Mills-2, Short Plat, SP-23-00002 Compliance Document

DRAWN BY CJG/MBG	MILLS-2 SHORT PLAT FOR: <b>MARK AND AMY MILLS</b>		JOB NO. 1223
CHECKED BY MBG	4640 W. DRY CREEK ROAD	ELLENSBURG, WA 98926	DATE 11/24/25
MBG Surveying P.O. Box 262 Coviche, Washington 98923 (509) 949-5797			SHEET 1
			OF 2

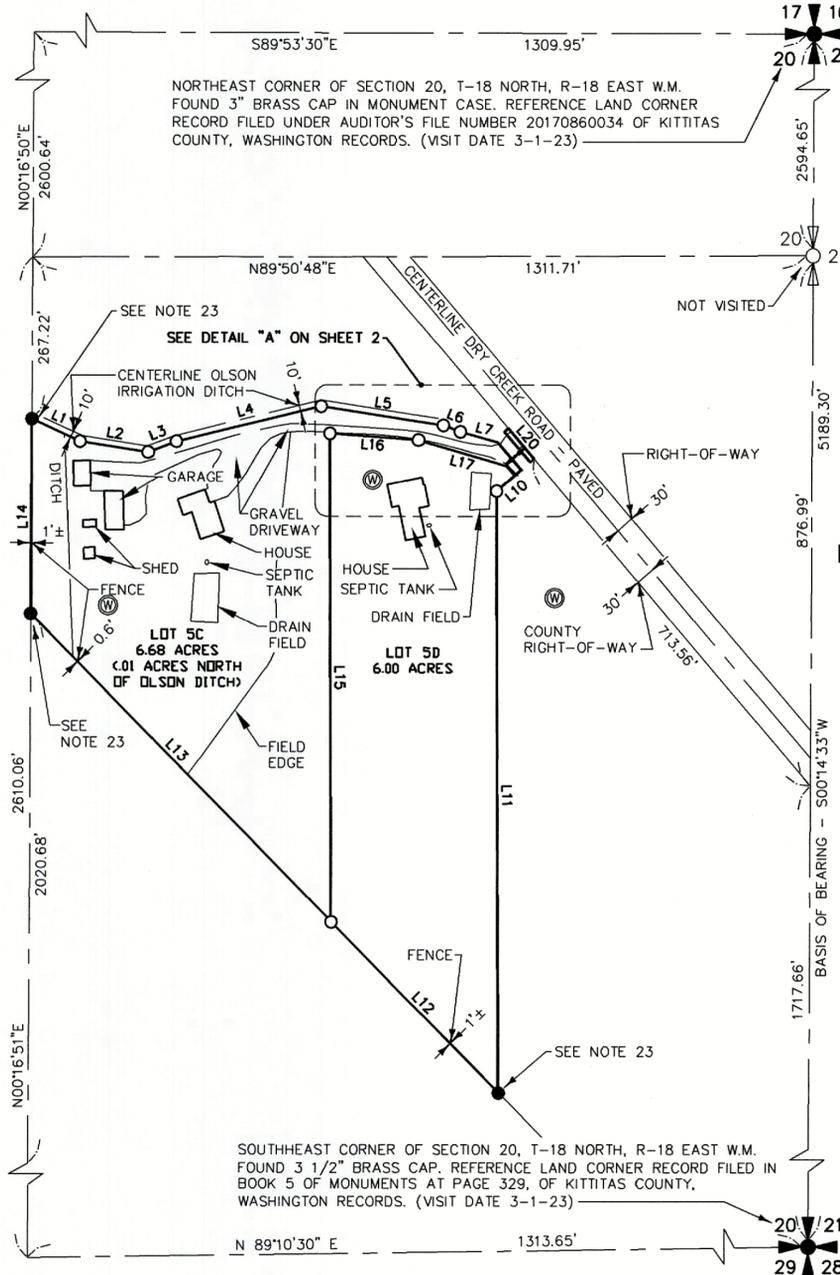
6. Survey D. Legibility of small text for the topo features on Lot 5C, Sheet 1. Please check minimum text height of 0.08"	Noted. Corrected	
6. Survey E. Legibility of line Tag labels on sheet 1 due to due to crossing linework and staggered Tag Labels.	Noted. Corrected

DRAWN BY CJG/MBG	MARK AND AMY MILLS SHORT PLAT FOR: <b>MARK AND AMY MILLS</b>		JOB NO. 1223
CHECKED BY MBG	4640 W. DRY CREEK ROAD	ELLENSBURG, WA 98926	DATE 11/24/25
MBG Surveying P.O. Box 262 Coviche, Washington 98923 (509) 949-5797			SHEET 2
			OF 2

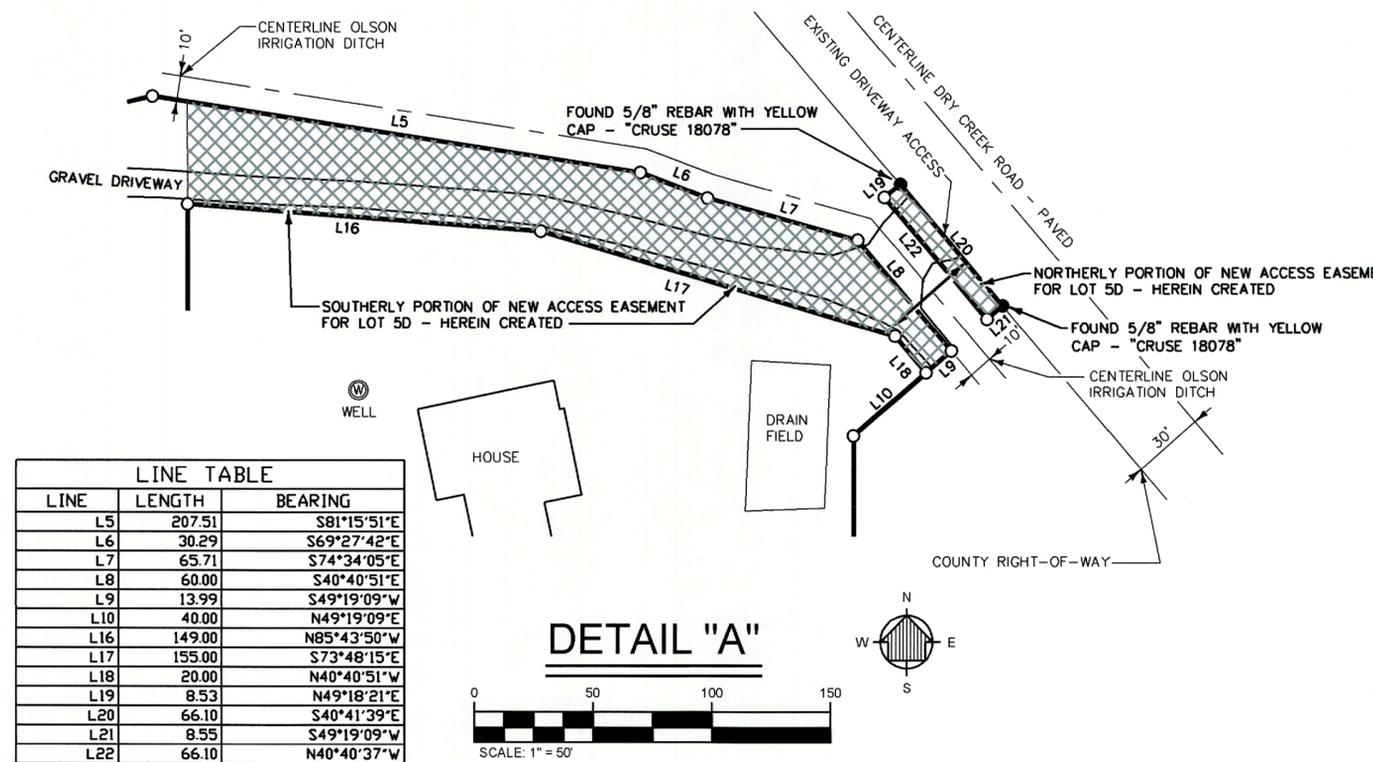
6. Survey G. Legibility of "Gravel Driveway" text on Sheet 2 due to hatching	Noted. Corrected	
6. Survey G. Please clearly identify Hatched area on Sheet 2 as the Access Easement, and identify it as "Herein Created" or "Created by separate document"	Noted. Corrected
